Planning Inspectorate reference: EN010142

**APPLICATION BY TILLBRIDGE SOLAR LIMITED FOR A DEVELOPMENT CONSENT  
ORDER FOR THE TILLBRIDGE SOLAR PROJECT**

**REQUEST TO CHANGE THE APPLICATION**

**Sheet Title**  
TRAFFIC REGULATION MEASURES KEY PLAN

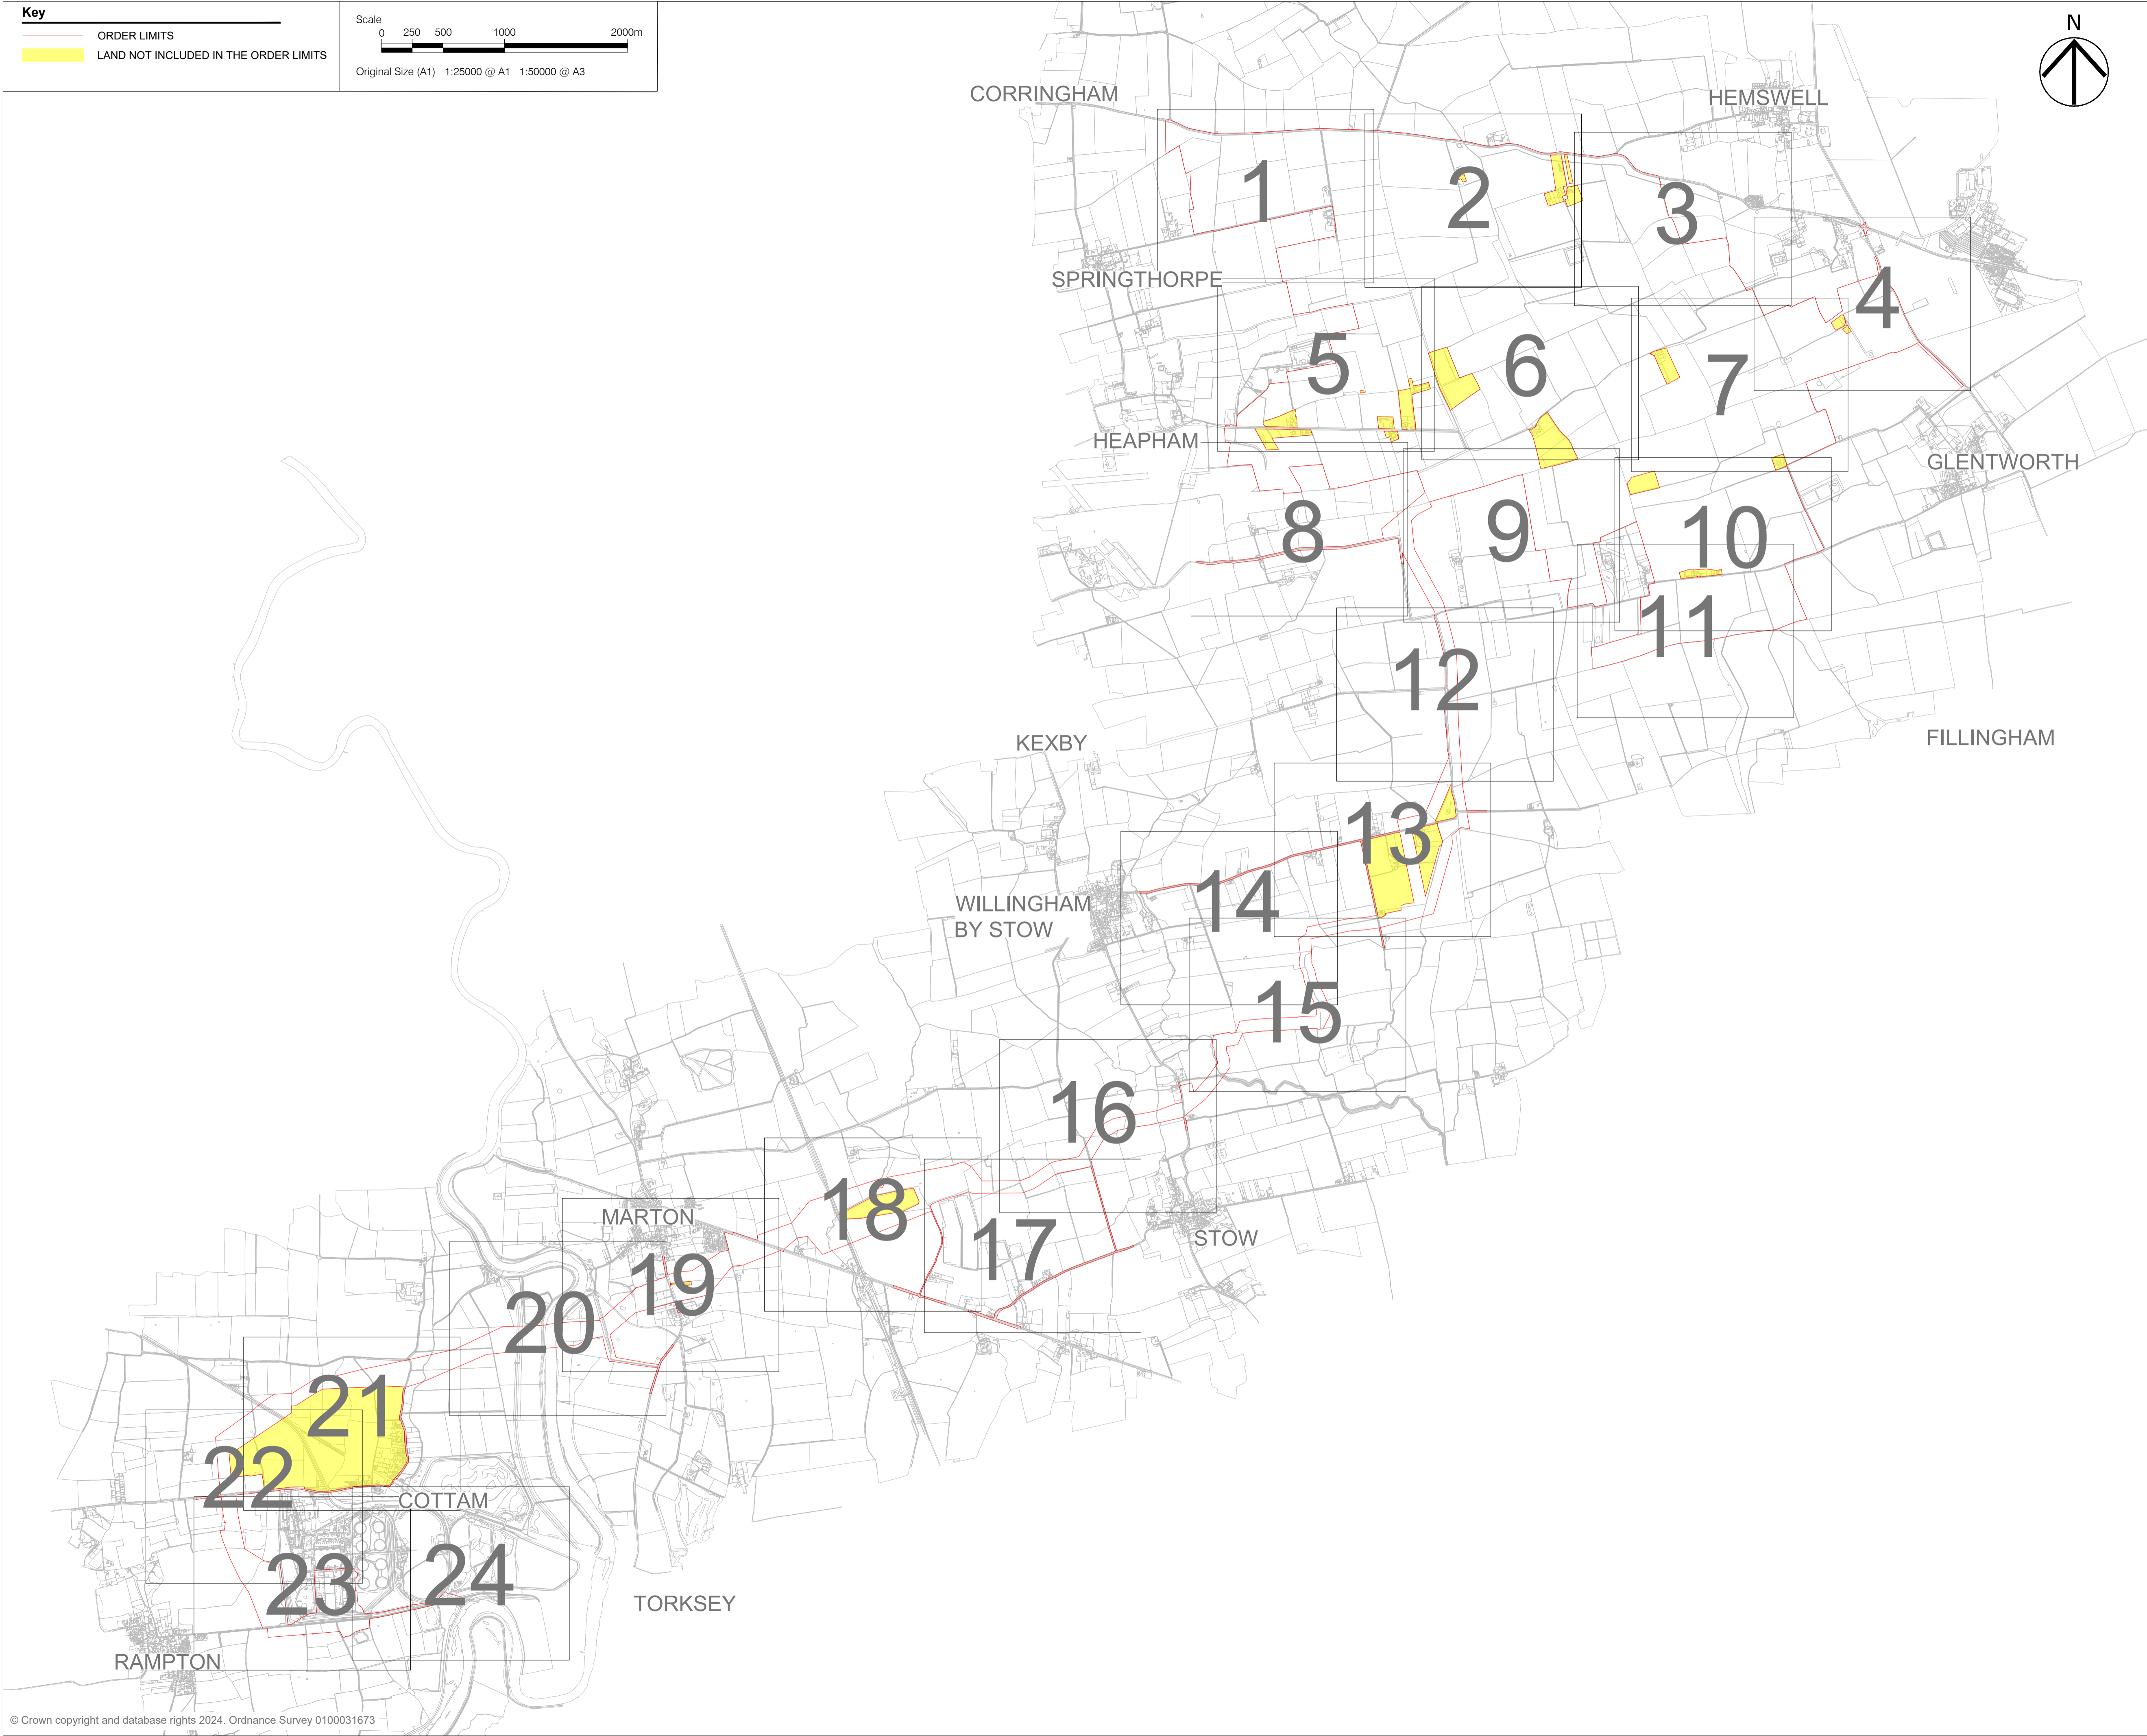
1. Reduction of the Order limits at east of B1241 Normanby Road and immediately south of East Farm (Change 1);
2. Reduction of the Order limits to the east of B1241 Normanby Road located to the north of Normanby by Stow. (Change 2);
3. Removal of triangular area of land from the Order limits to the north of Willingham Road (Change 3);
4. Reduction of the Order limits to remove part of Torksey Ferry Road (Change 4);
5. Refinement of the Scheme layout and design to create two additional accesses off School Lane (one temporary and one permanent). No change to the Order limits arising (Change 5);
6. Removal of highway extents from Order limits along Northlands Road and Kexby Road (Change 6);
7. Removal of highway extents from Order limits along the A631 Harpswell Lane (Change 7);

8. Removal of highway extents from Order limits along B1398 Middle Street (Change 8);
9. Reduction of the Order limits on land to the north of Common Lane (Change 9);

**Sheet Title**  
TRAFFIC REGULATION MEASURES PLANS SHEET 1 OF 24

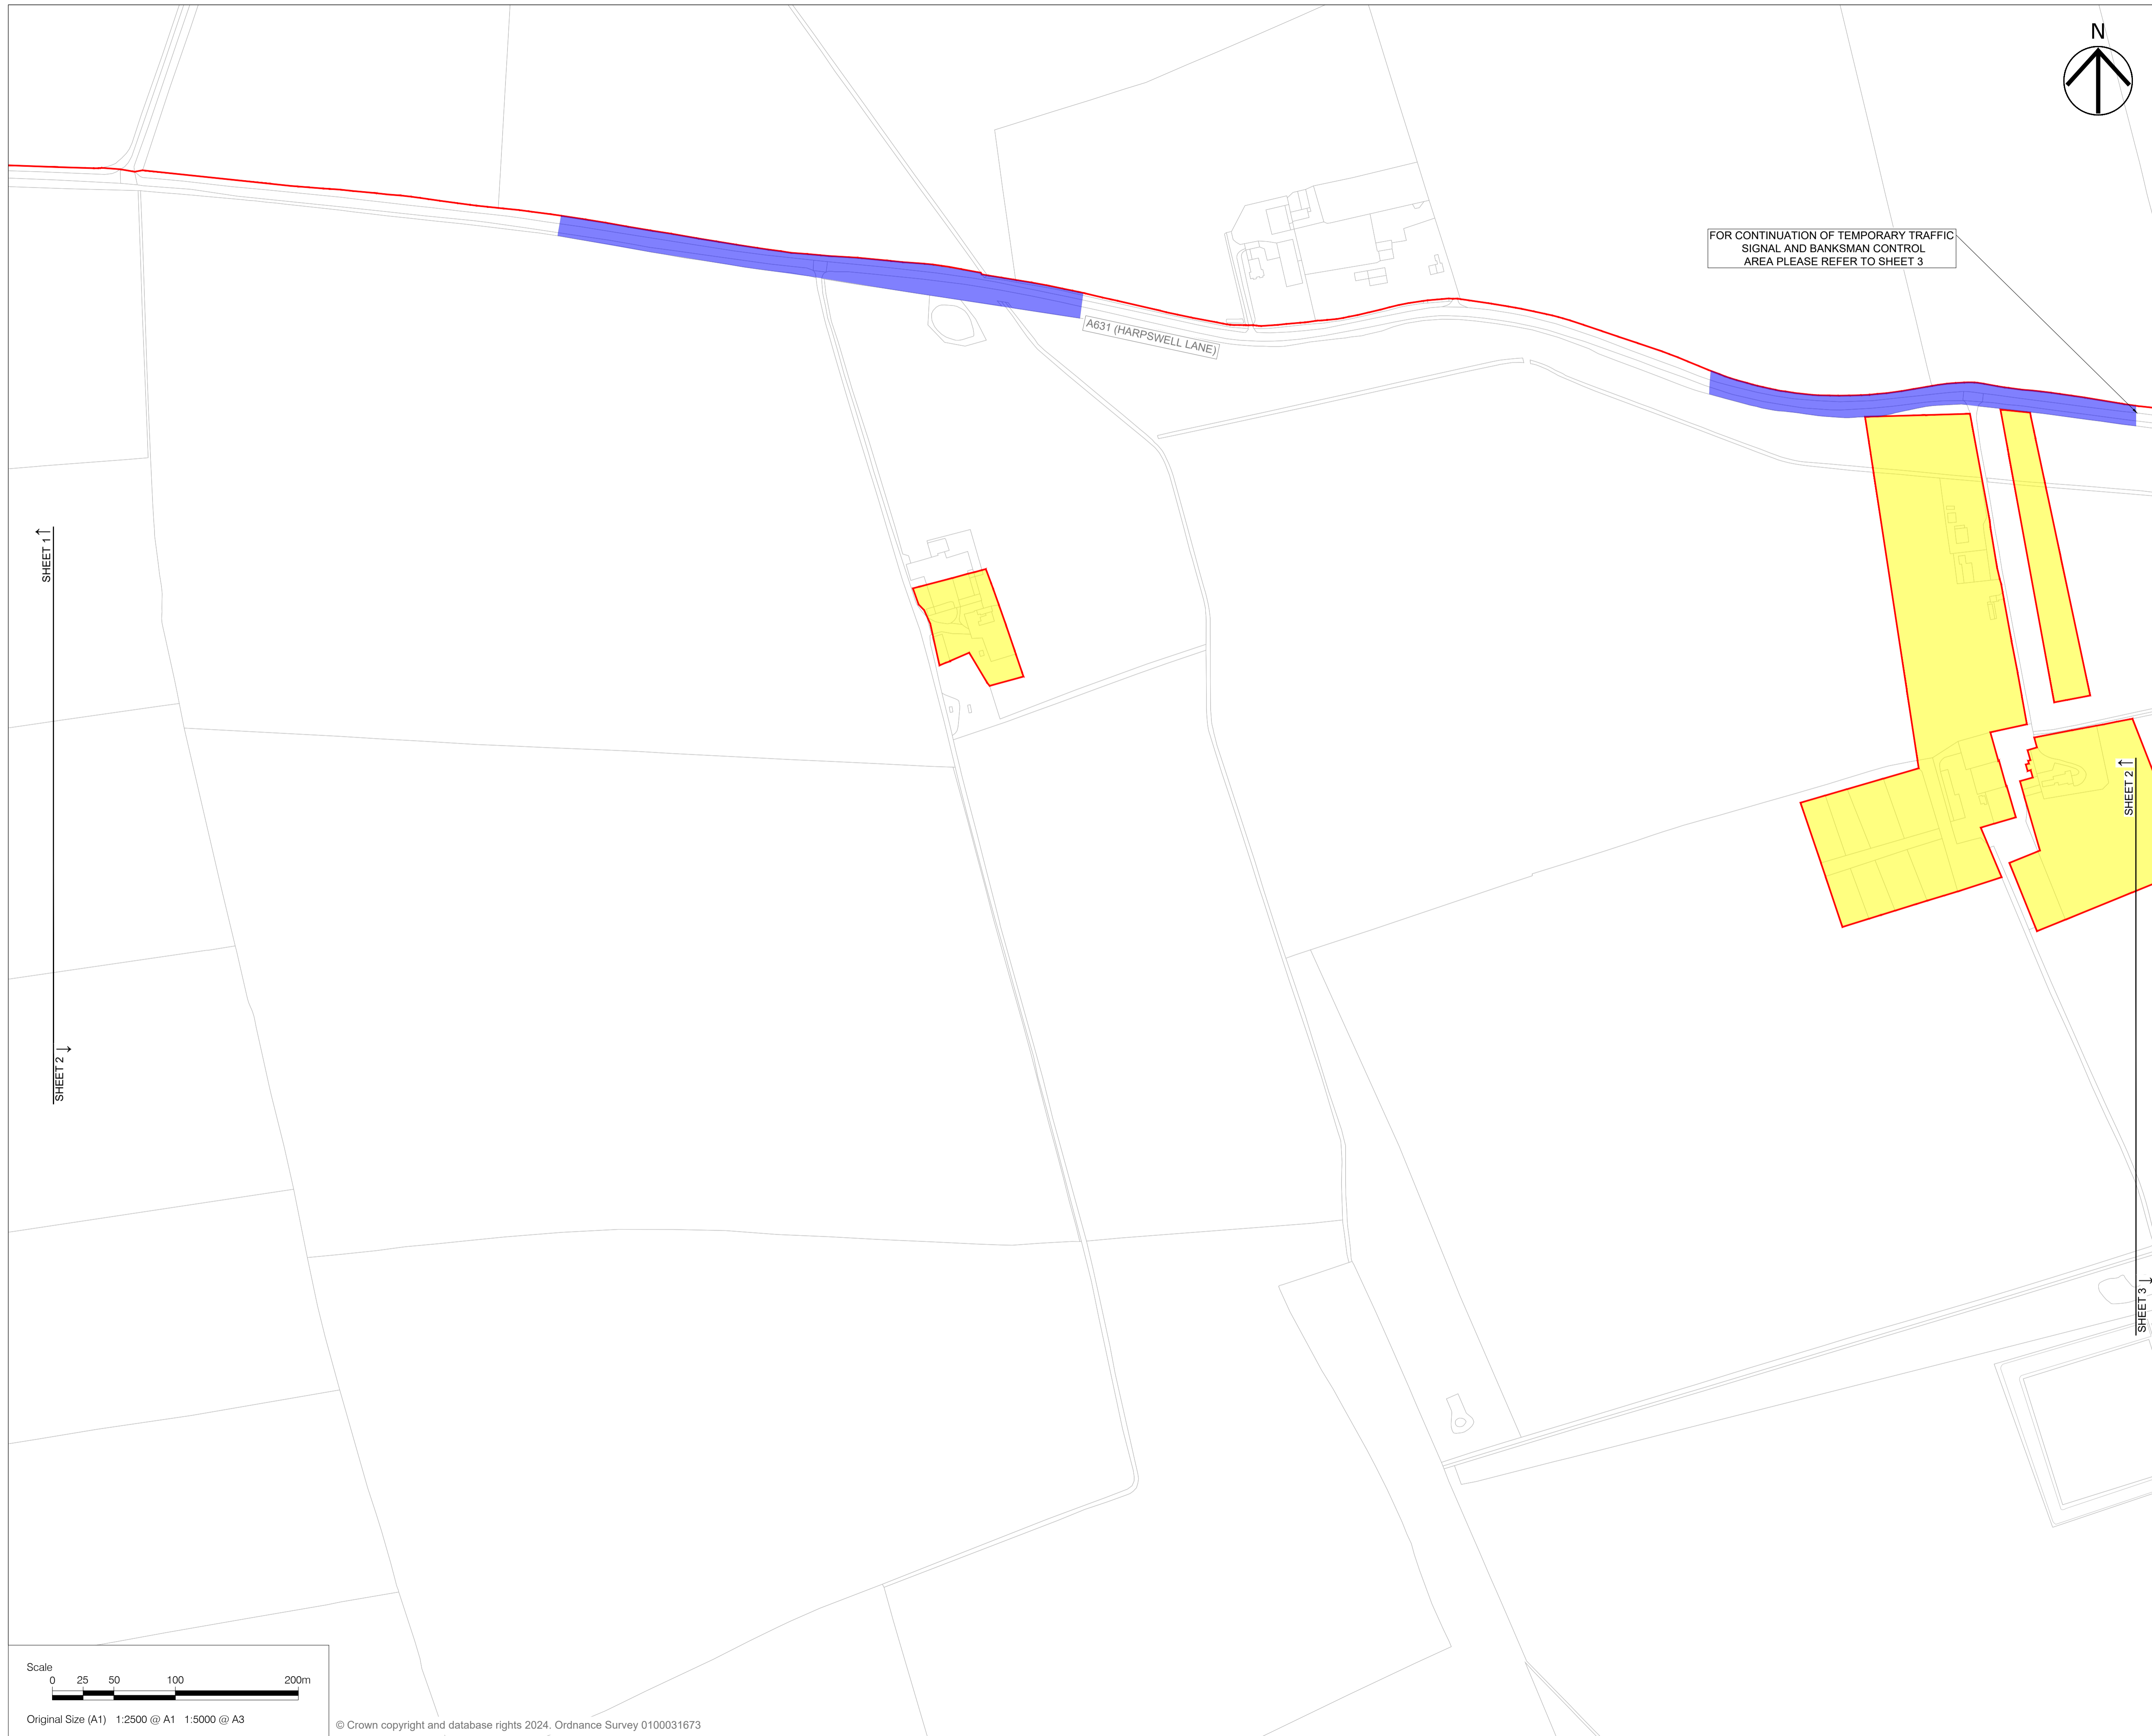
14. Removal of land from the Order limits on land to the south-west of Marton adjoining the River Trent (Change 14);
15. The diversion of construction and decommissioning traffic from an existing access serving the Pickering & Son Farm located to the south off the A631 (Harpswell Lane) to an existing track serving Harpswell Low Farm, located west of the Pickering & Son Farm south off the A631 (Harpswell Lane). The access serving the Pickering & Son Farm will remain for operational use only (Change 15).
